V1_Soils & Geology Report_COMMENTS.pdf Markup Summary

Subject: Planner
Page Label: [1] SITE PLAN 8.5X11
Author: dsdparsons
Date: 8/19/2026 2:50:32 PM
Status:
Color: ■
Layer:
Space:

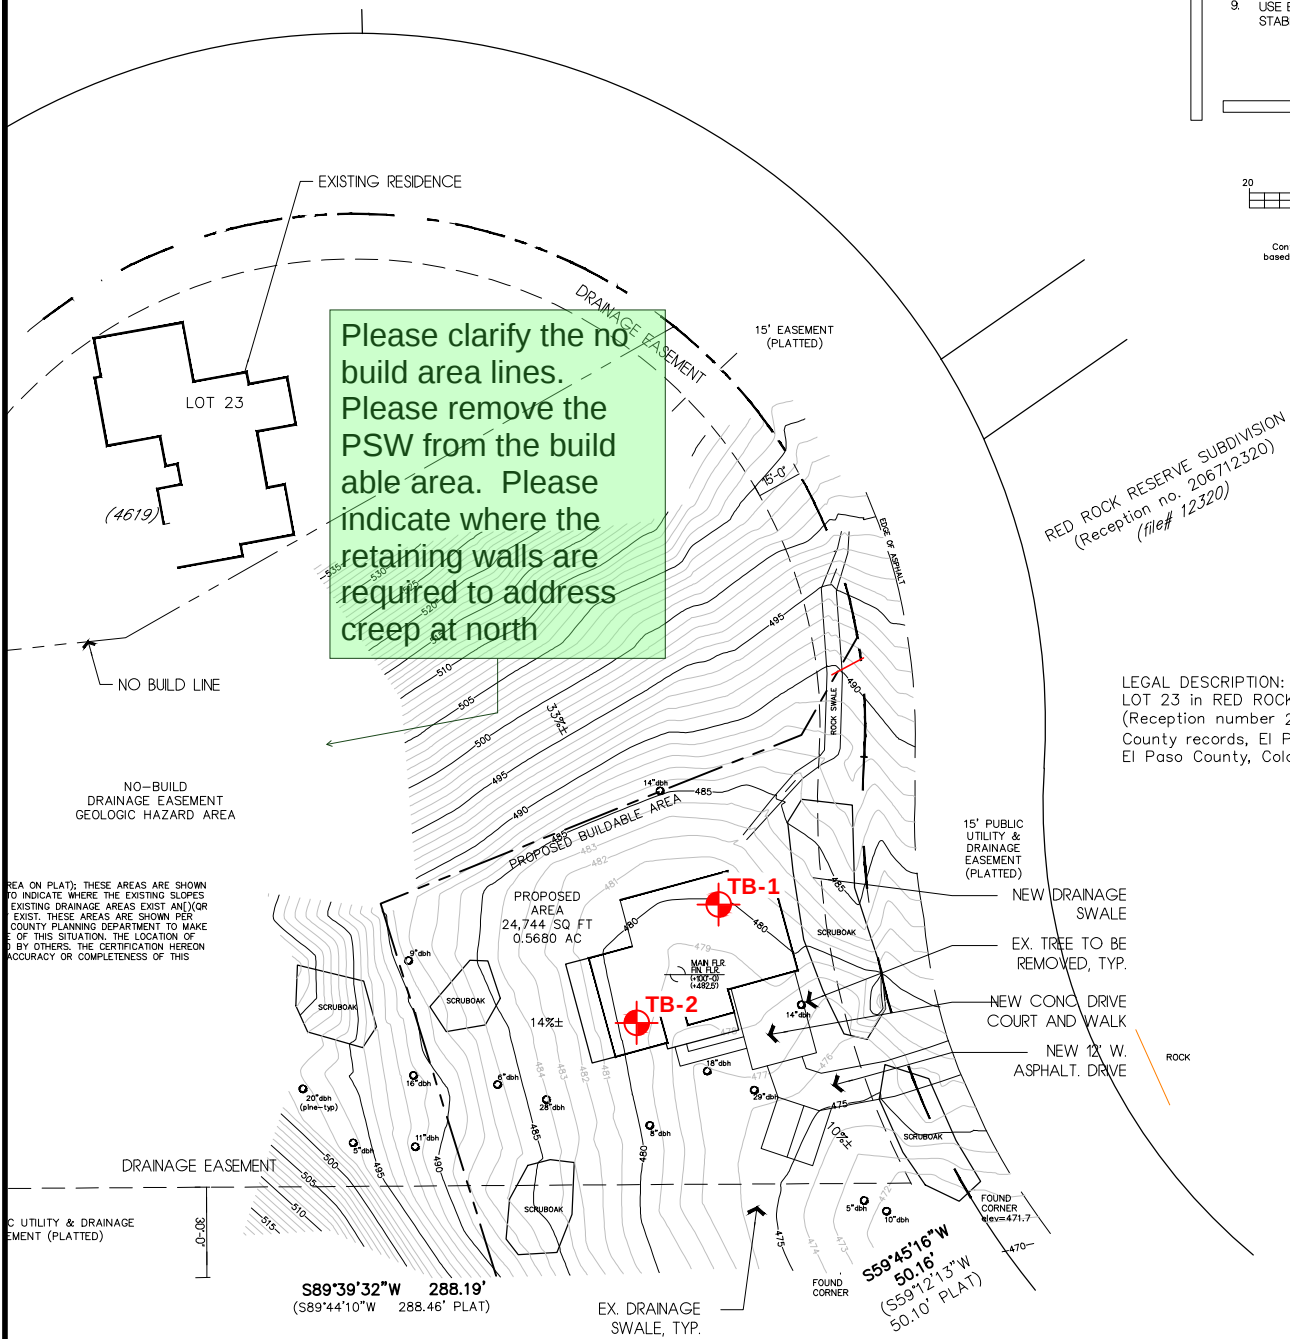
Please clarify the no build area lines. Please remove the PSW from the build able area. Please indicate where the retaining walls are required to address creep at north

Please clarify the no build area lines. Please remove the PSW from the build able area. Please indicate where the retaining walls are required to address creep at north

Is this the limit of downslope creep? please move no build lines to match or provide wall location and recommendations

the proposed drainage way needs to be in a no build area please correct

This is in the drainage easement

089°30'30"W 294°10'
089°30'30"W 294°10'
How will this corner be stabilized?
locene Age: sheetwash and residual soil
in-situ weathering of the bedrock material
locene Age overlying the Dawson Formation
lacustrine Age: sheetwash and residual
to arkosic sandstone with interbedded

How will this corner be stabilized?
